From: dane@tnesinc.com
Sent: Monday, August 13, 2018 3:54 PM
To: Marc Whorton
Cc: 'Luanne Ducett'
Subject: Timberridge Estates - Revised Drainage Report and Comment Responses
Attachments: 173300 FDR.pdf

**PRELIMINARY/FINAL DRAINAGE REPORT
FOR
TIMBERRIDGE ESTATES, PRELIMINARY PLAN
PART OF THE RETREAT AT TIMBERRIDGE
(NORTH OF ARROYA LANE)**

TNE Job No. 1733.00
County Job No. SP-18-002

THE RETREAT AT TIMBERIDGE
PRELIMINARY DRAINAGE REPORT
(SOUTH OF ARROYA LANE)
DEVELOPED DRAINAGE MAP

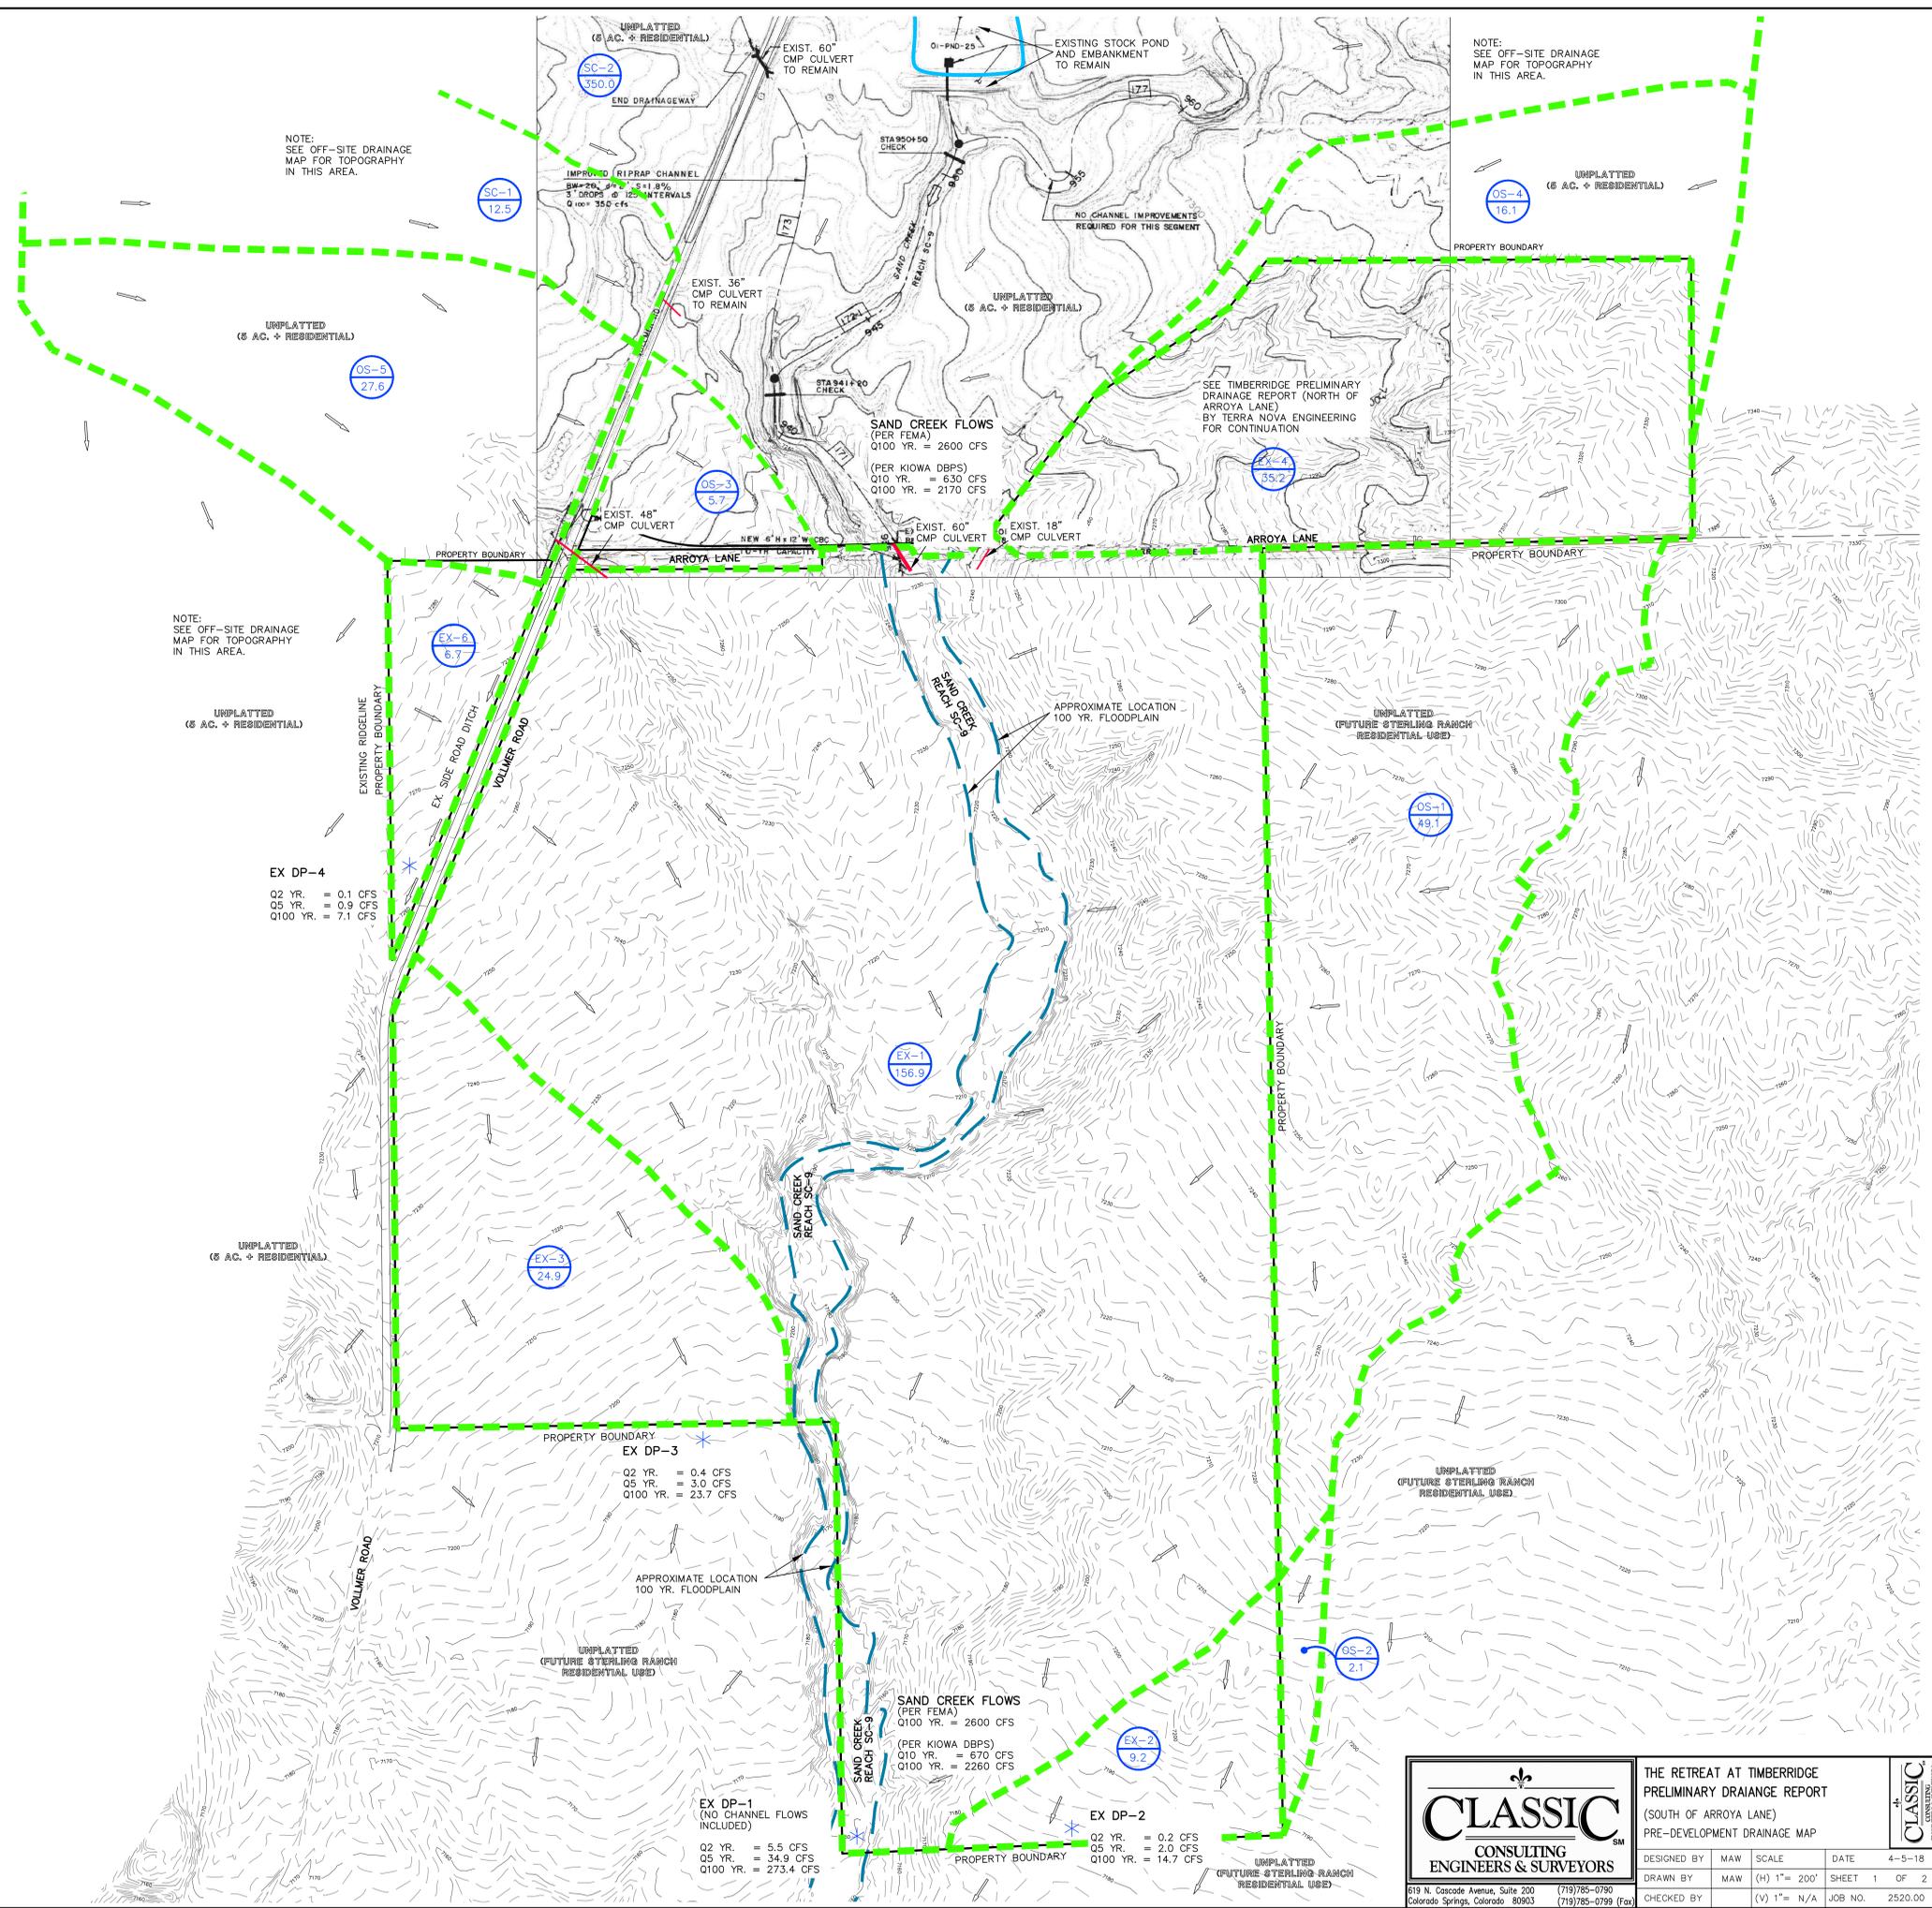
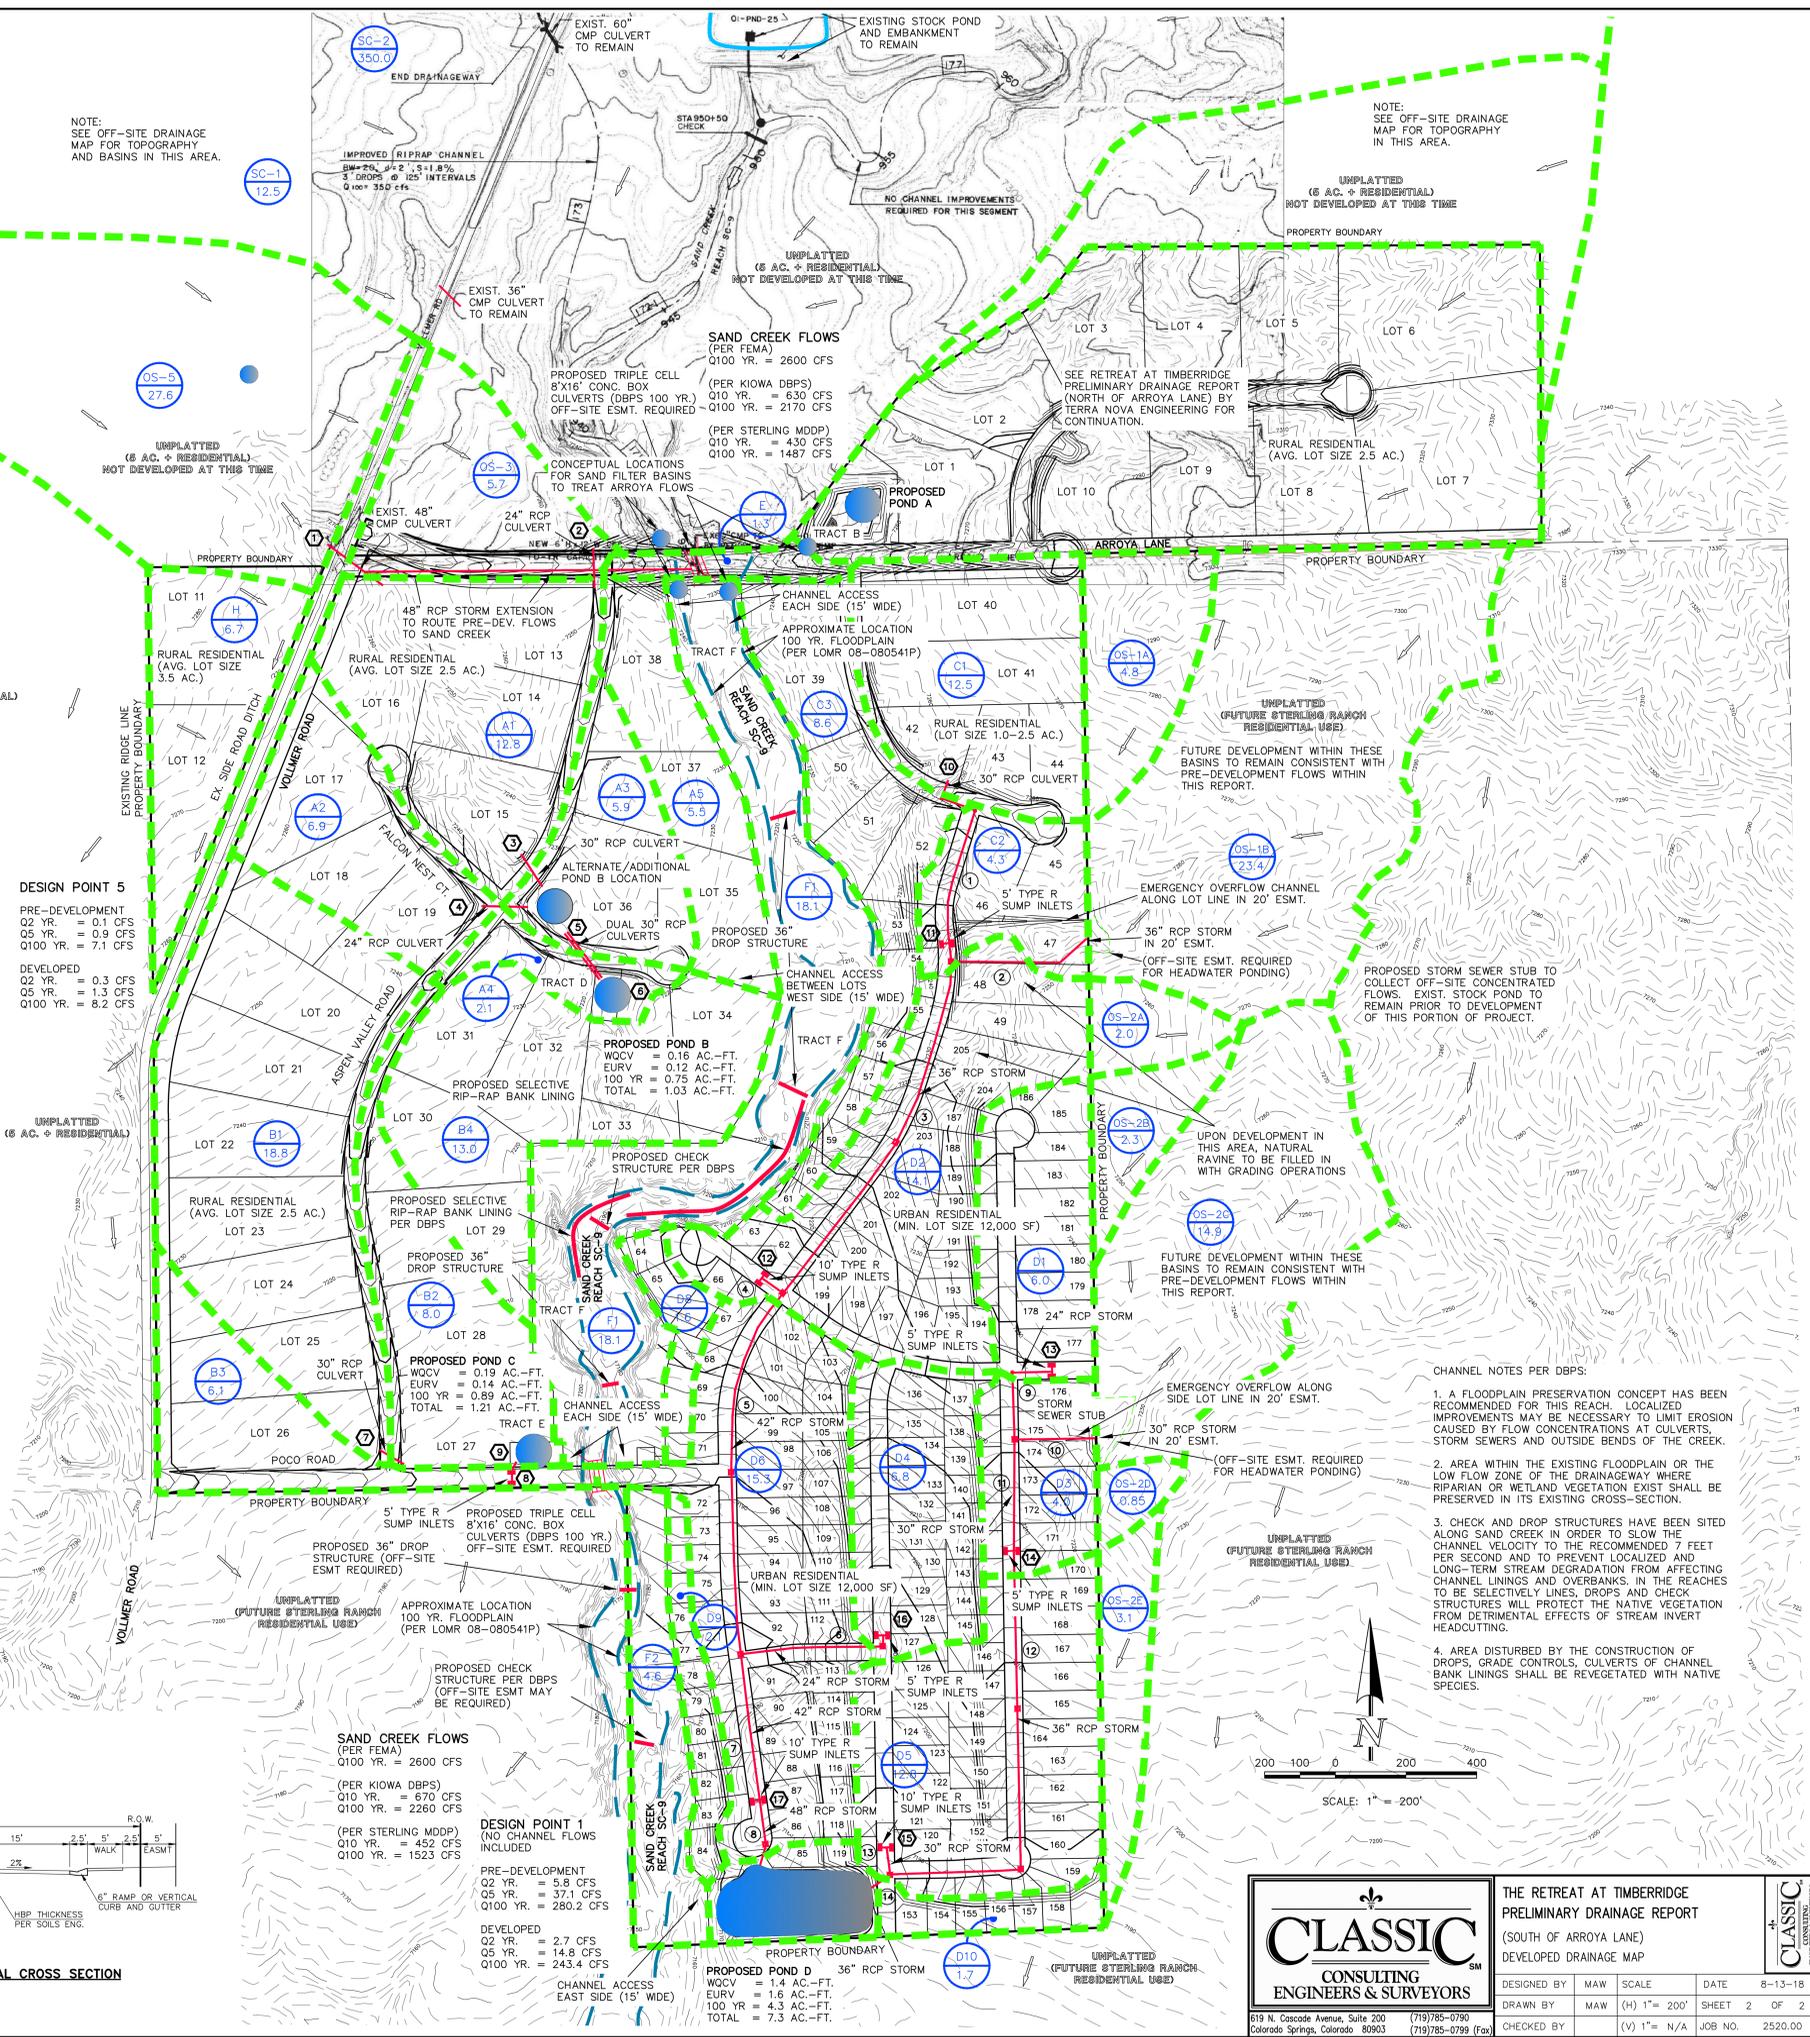
C: On the proposed drainage plan, there is a comment saying label type and dimension of outfall stabilization.

C: On the proposed drainage plan, this is a question of these are identified as no build areas, why are you disturbing these drainage ways?

C: On the proposed drainage plan, there is a comment saying stabilized spillway outfall needs to be entirely within the property.

C: On the proposed drainage plan, there is a comment saying PR Asphalt (after Arroya Lane, EX dirt road).

R: See the extended detention basin detail in the top left corner of the sheet.

R: The existing drainage channels flatten out in a number of places, which resulted in very wide drainage easements. The developer directed us to grade some of the existing channels so the easements weren't covering large portions of several of the lots.

R: This isn't possible since the drainage channel the spillway discharges into is mostly in the public ROW. I've added erosion protection to that section of the channel, but no matter where the spillway goes, it has to discharge water to the channel in the ROW.

R: Paving Arroya Lane is not part of the Timberridge Estates development. Last I heard, Arroya Lane wasn't getting paved until phase 3 of the Retreat at TimberRidge, while Timberridge Estates is phase 1.
